Ribble Valley Borough Council
Housing & Development Control

Application no: **3/2020/0089**

Address: **17 Hillcrest Road Langho BB6 8EP**

Proposal: **Dormer to front, single storey porch to front, single storey extension to side**

GROUND FLOOR PLAN PROPOSED

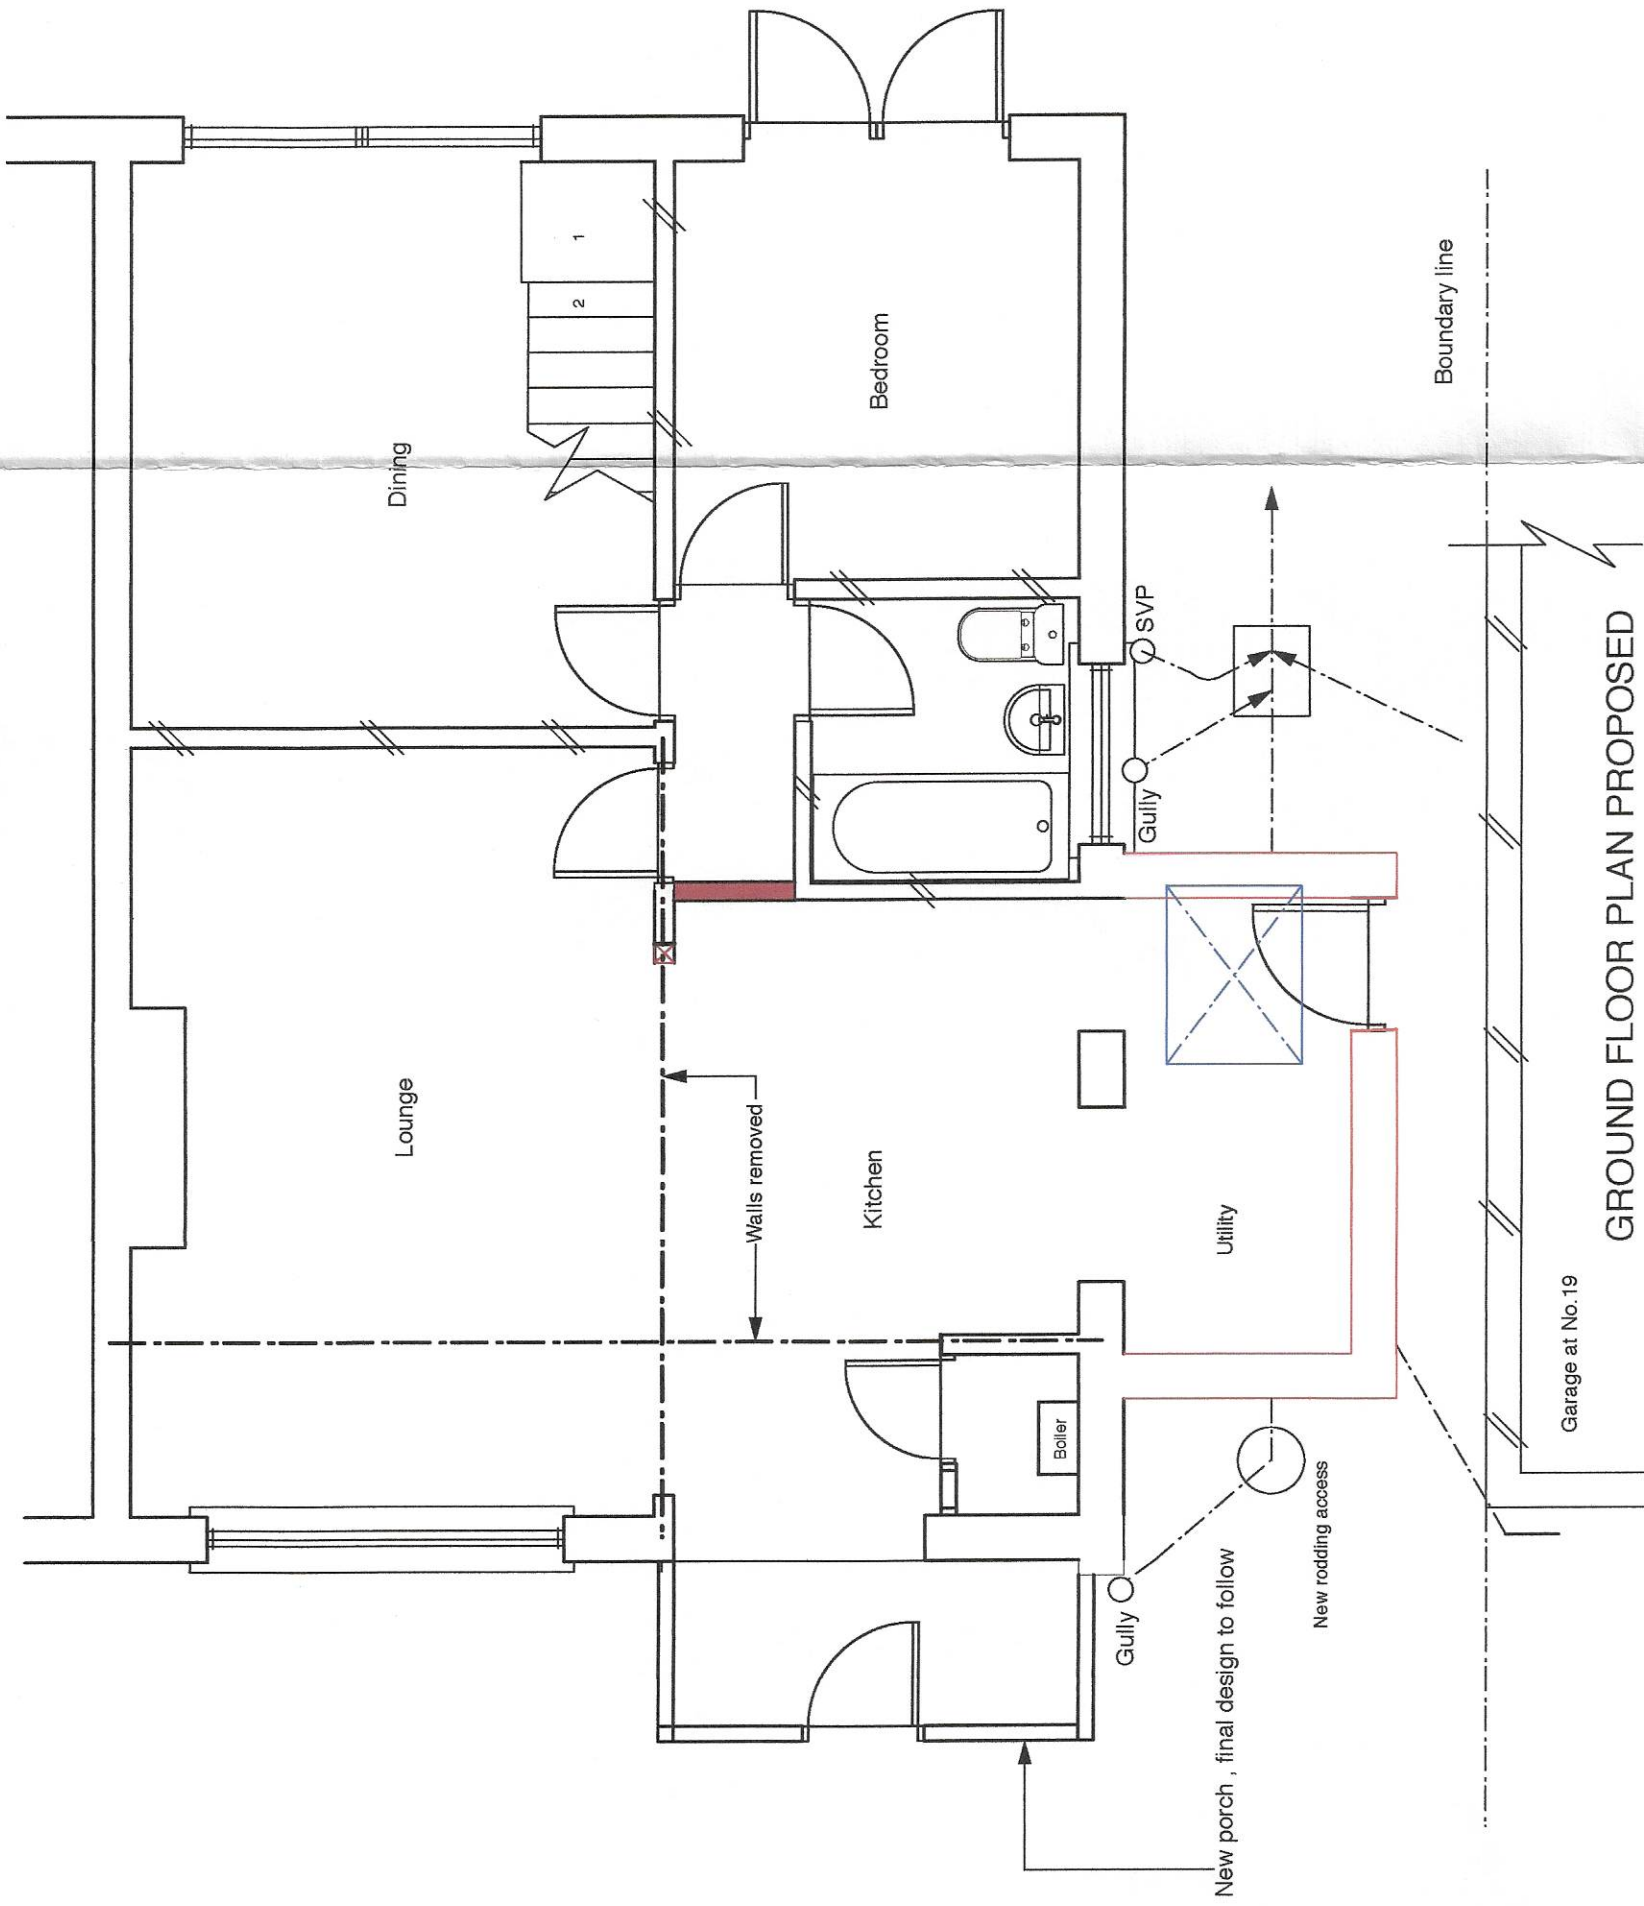
The applicant proposes to reduce the length of the existing driveway by the introduction of a single storey side extension which will restrict vehicular access to the existing garage positioned to the rear of the dwelling. The applicant is therefore

required to demonstrate how they can accommodate three parking space within the curtilage of the property.

SITE PLAN PROPOSED
Scale 1-100

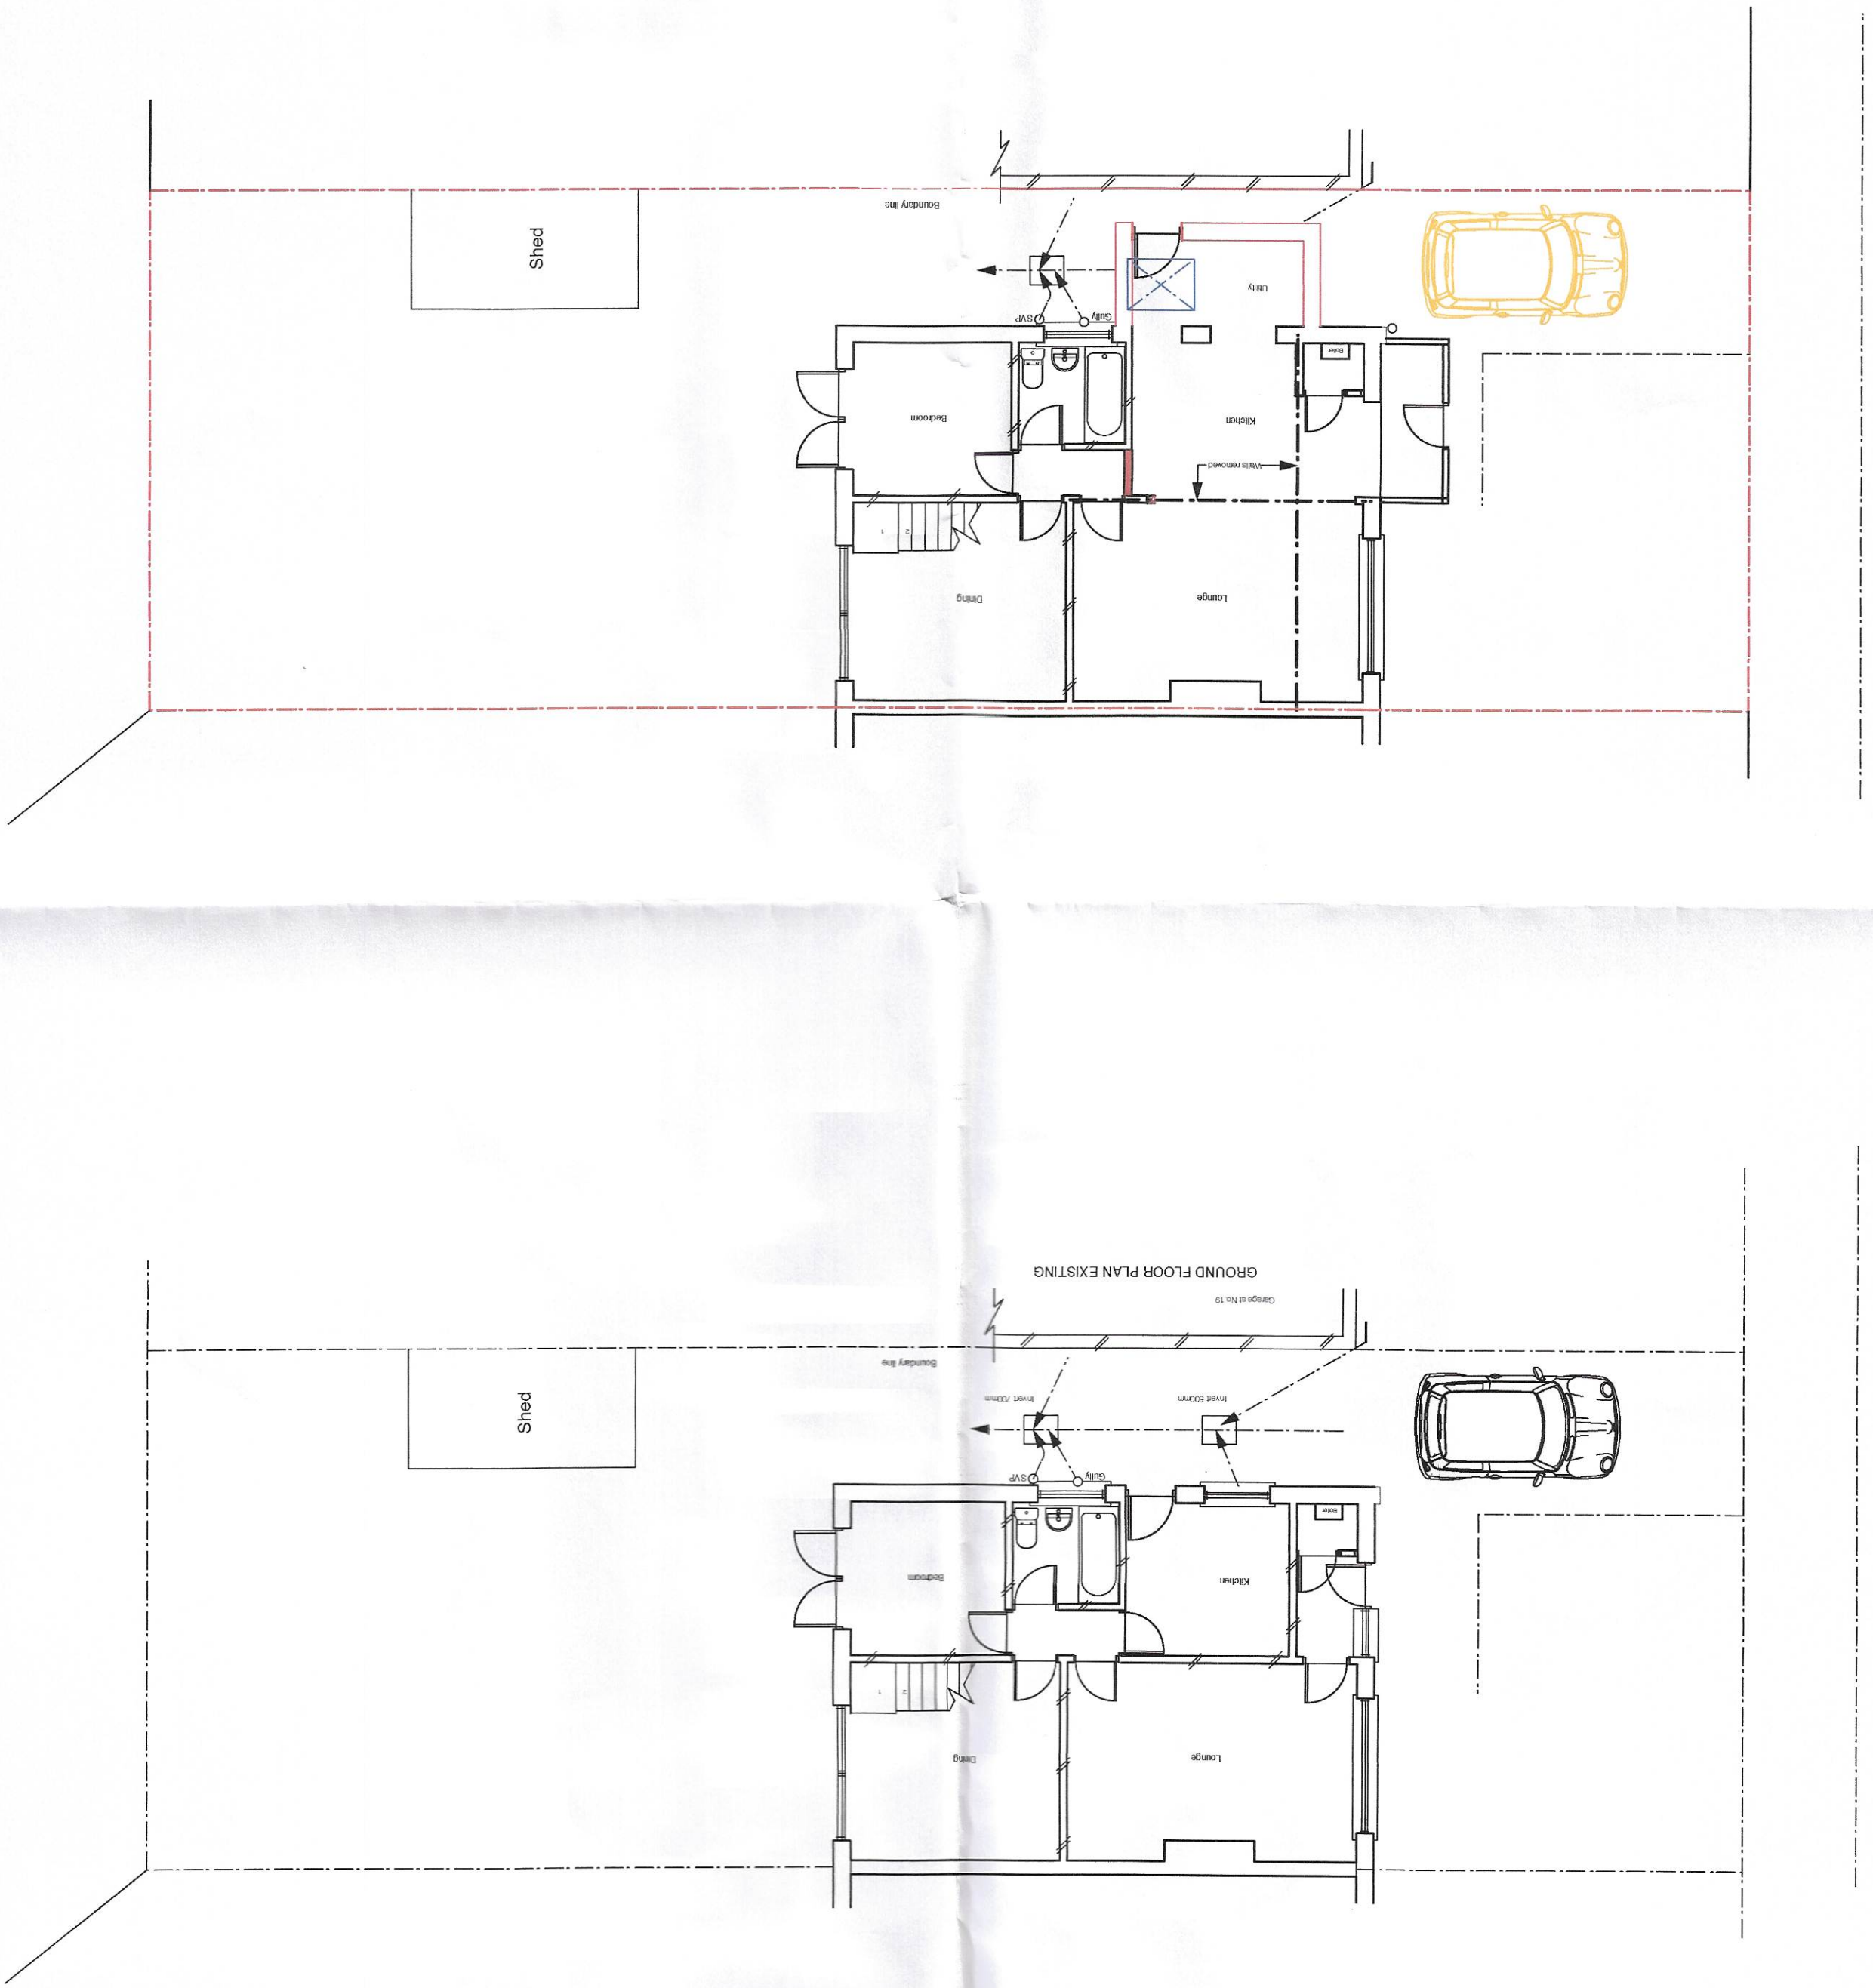
Should perpendicular parking be proposed, then an extension to the existing vehicular dropped crossing will need to be installed prior to the driveway first being first used for vehicular purposes.

I would ask that the plans are revised.
